Requested Revisions for 86 Morning Street Permit Application

Attached please find the updated drawings addressing all of your redlines for the renovation of 86 Morning Street. We now plan to demolish the garage, as it is not salvageable.

6 SHOWER
Scale: 1/2" = 1'-0"

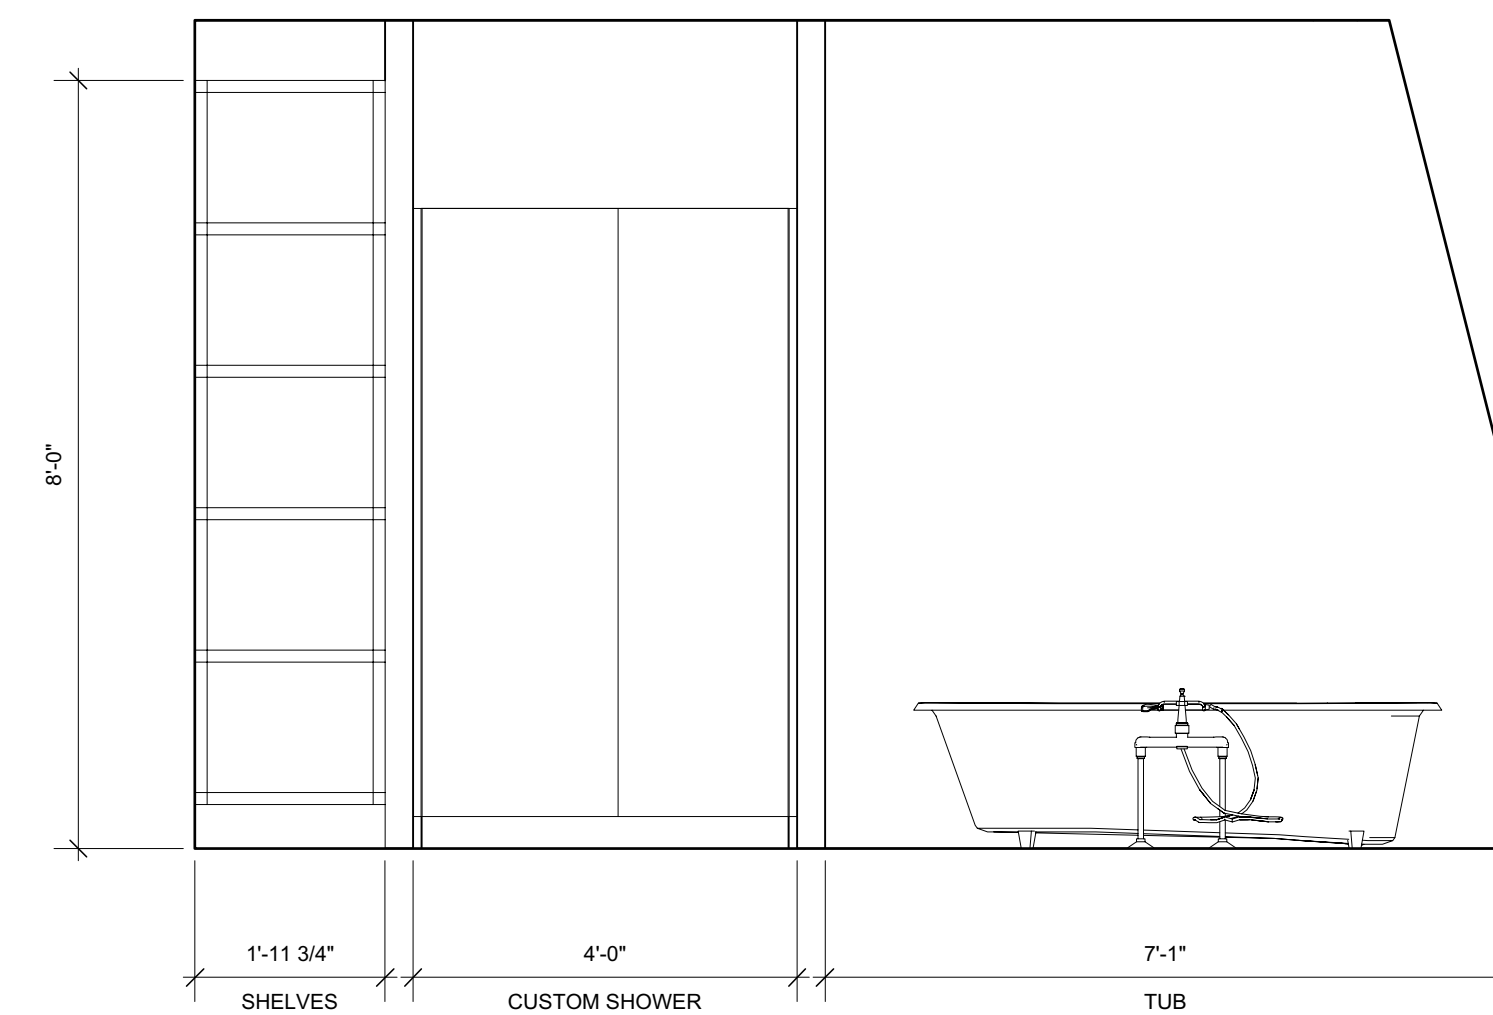
We have separated the Kitchen from the Bathroom interior elevations, so the tempered glass that is required at the bath tub originally shown on A4.1 is now illustrated on sheet A4.3.

- Note referencing tempered glazing at tub as shown on A4.3
-

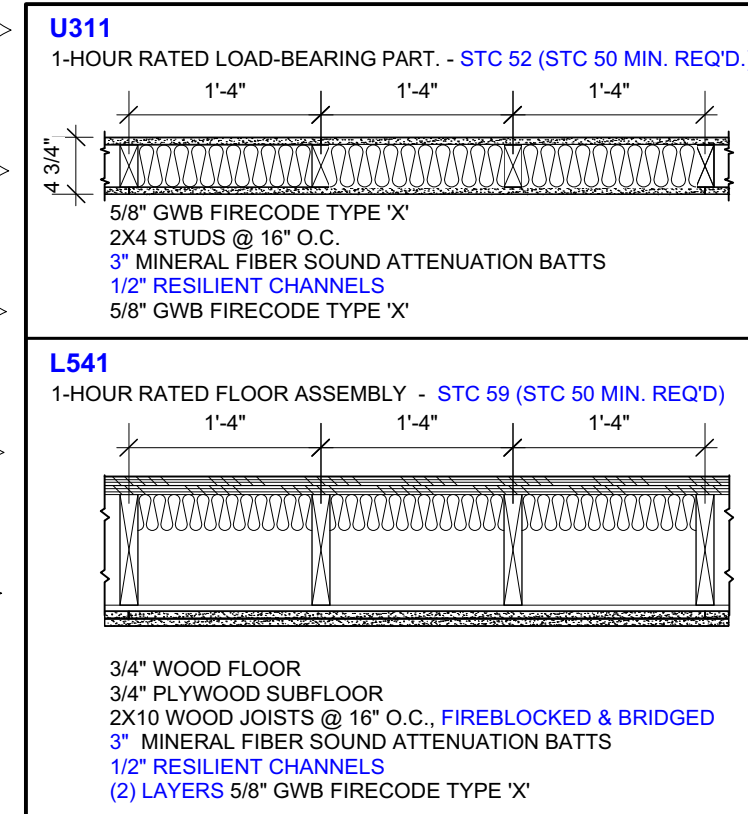
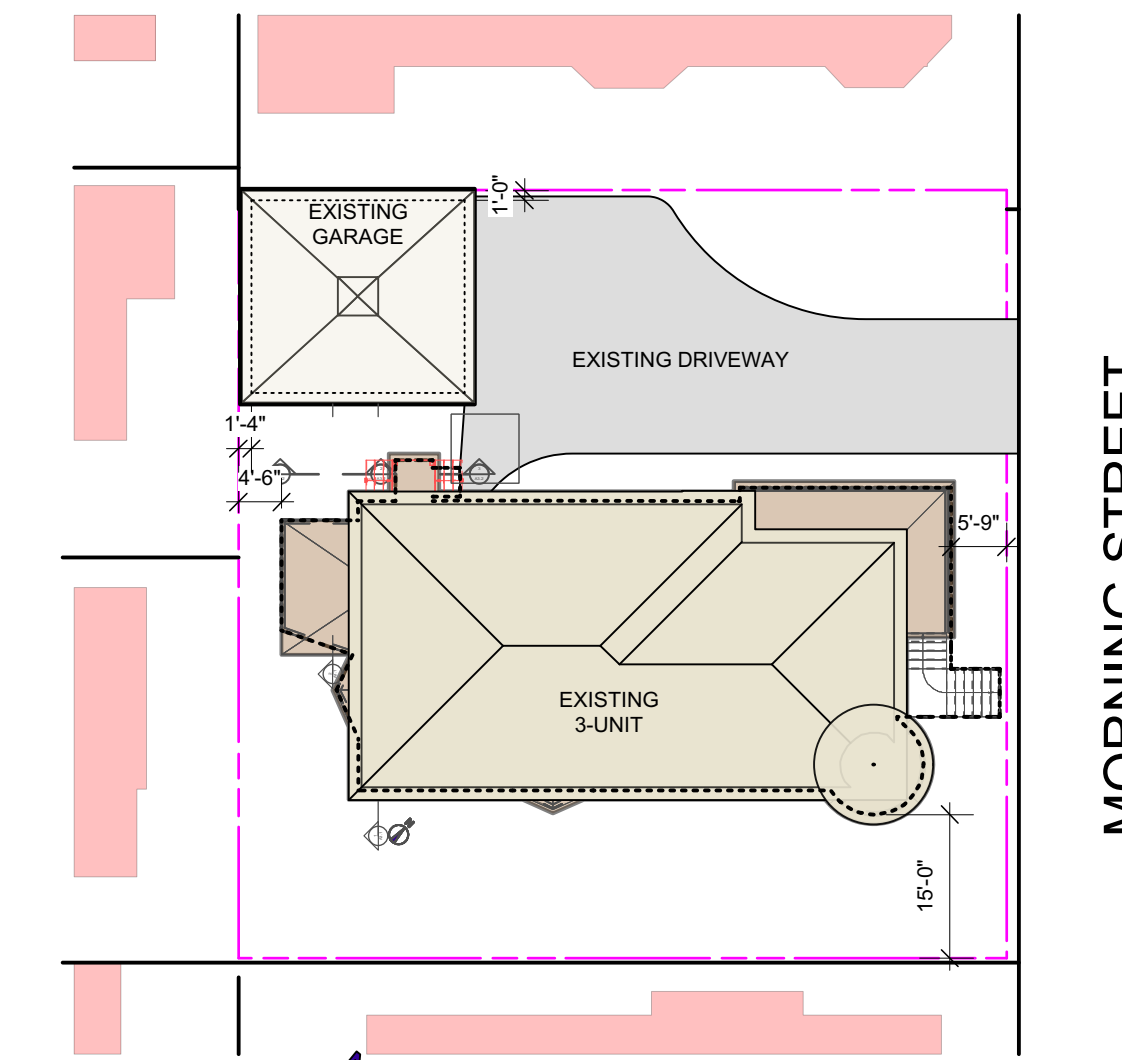
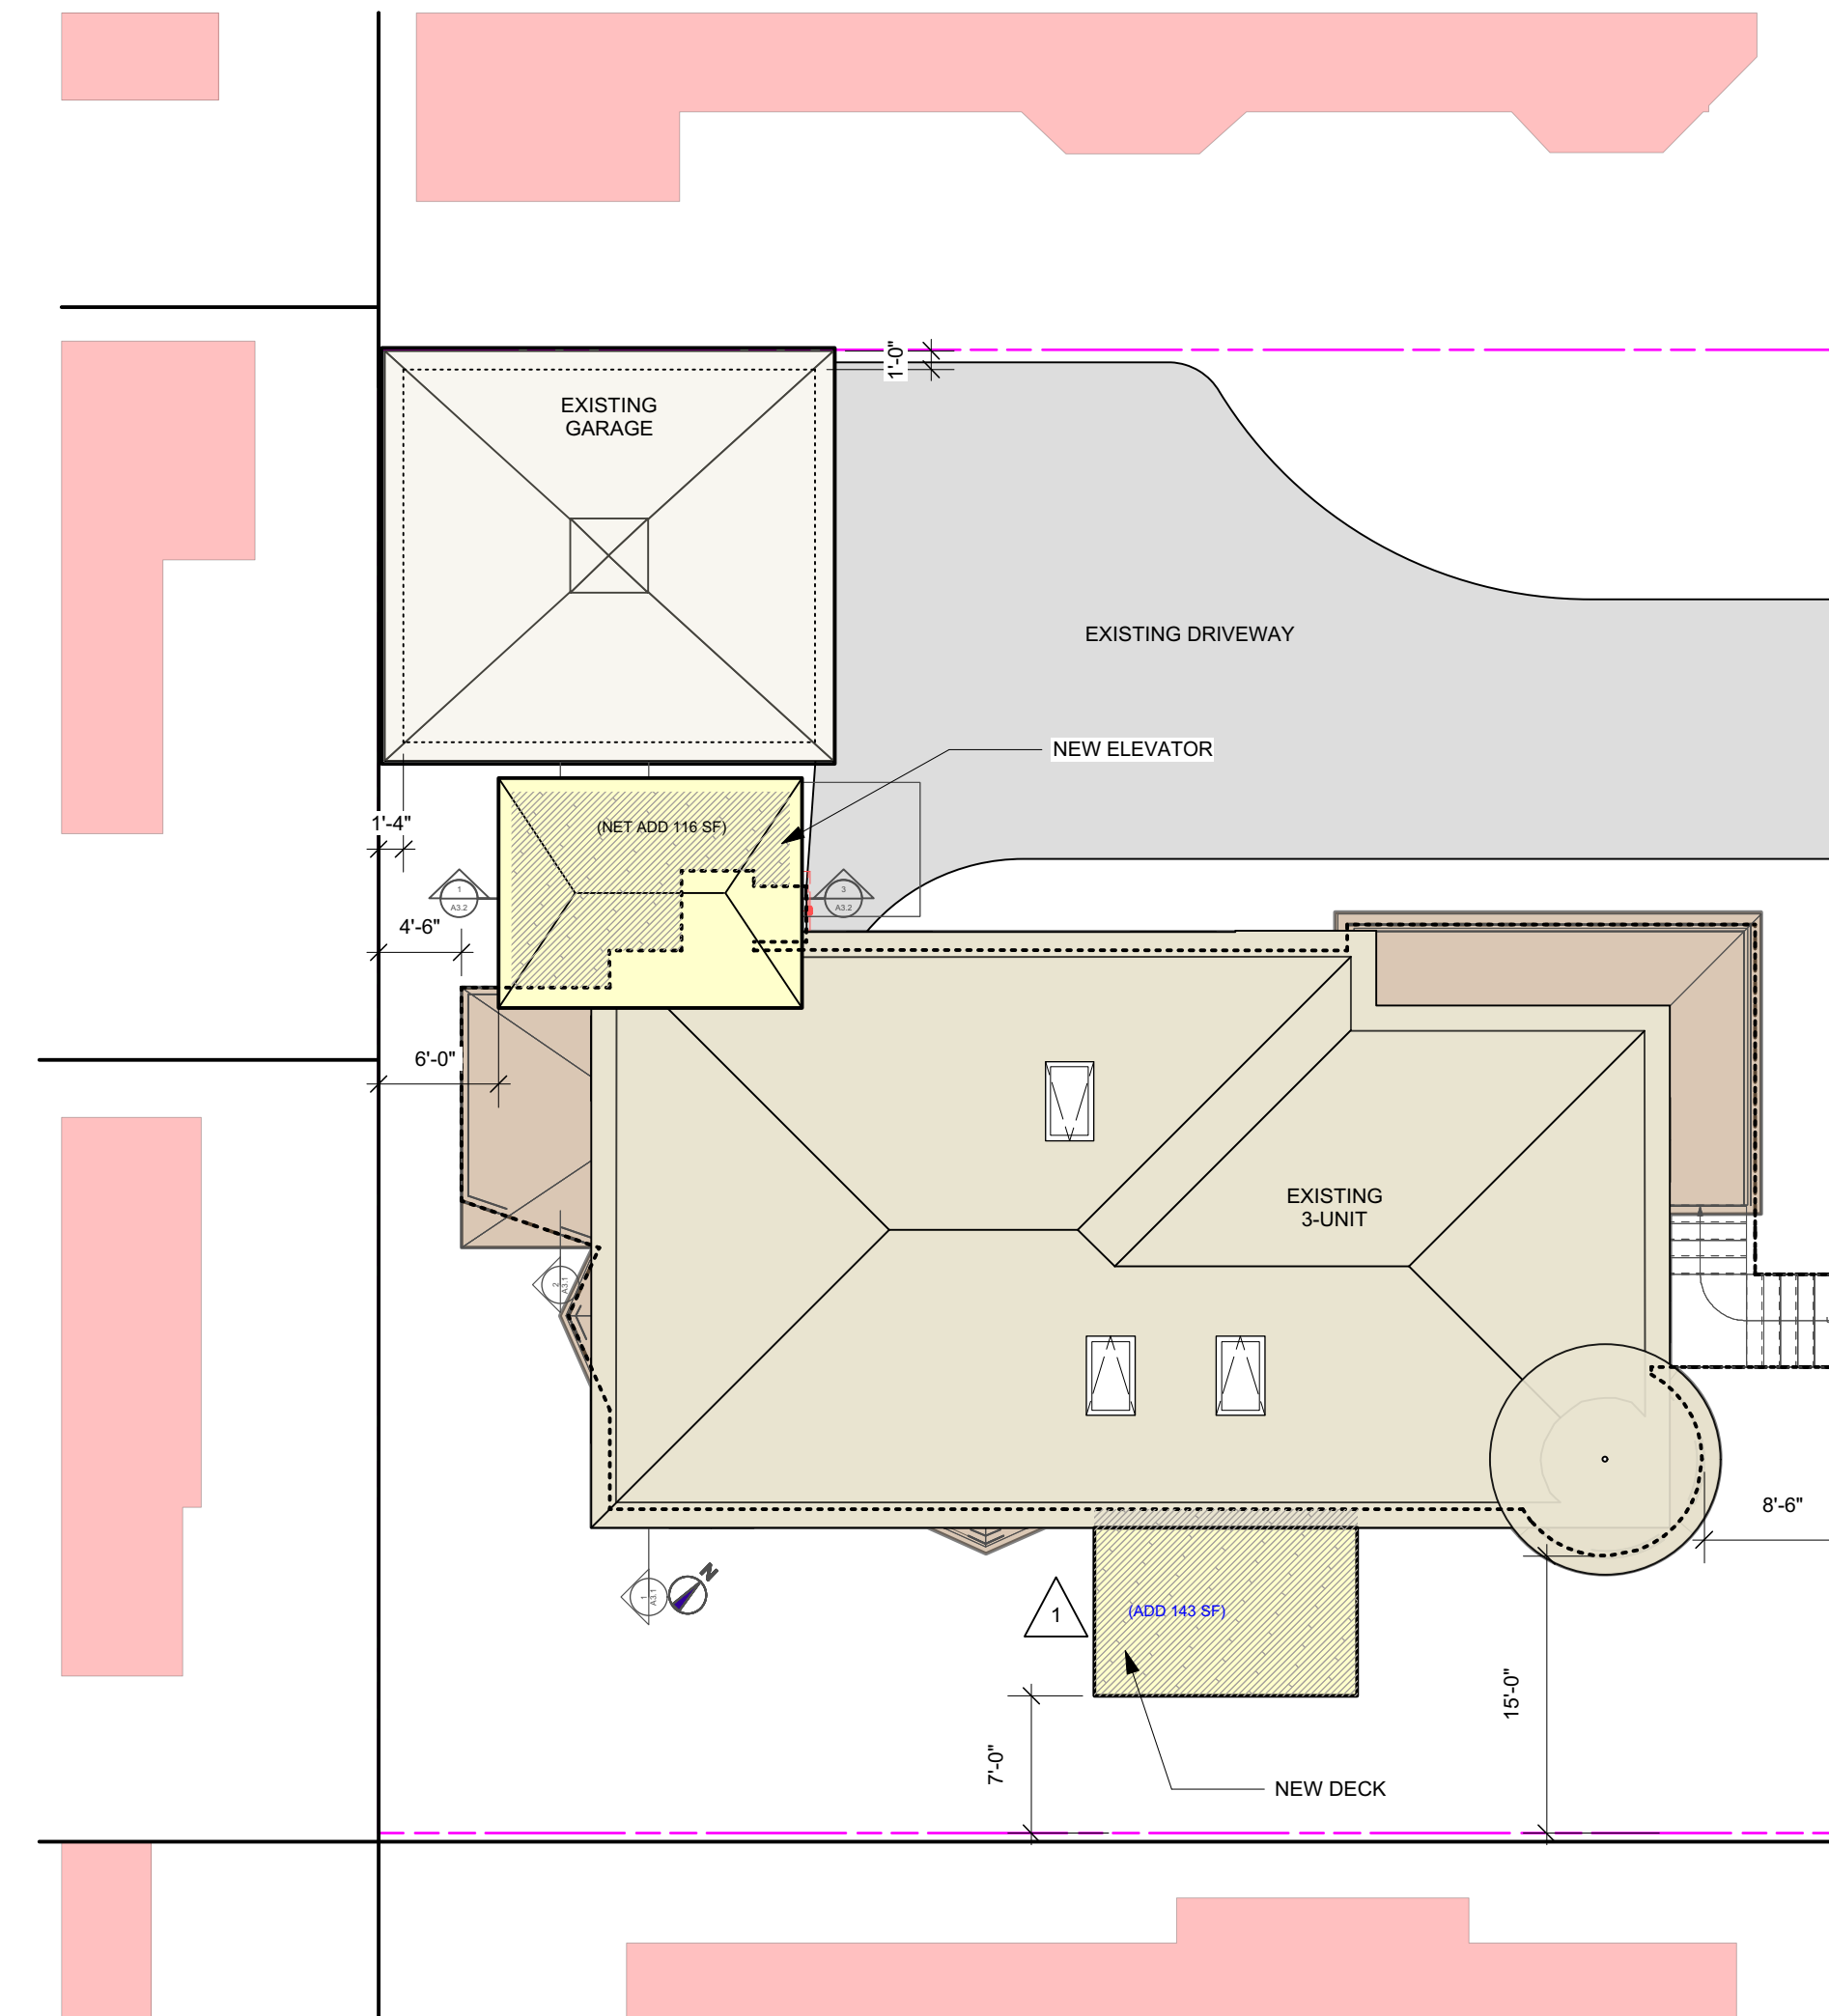
- STC rating of UL Listed Assemblies
- Exterior wall rating requirements for <5' separation per Table 602
- Corrected square footage of the deck
- Note explaining that the garage will be demolished under a separate permit, already filed.
- Addition of Sheet A4.3 to drawing list
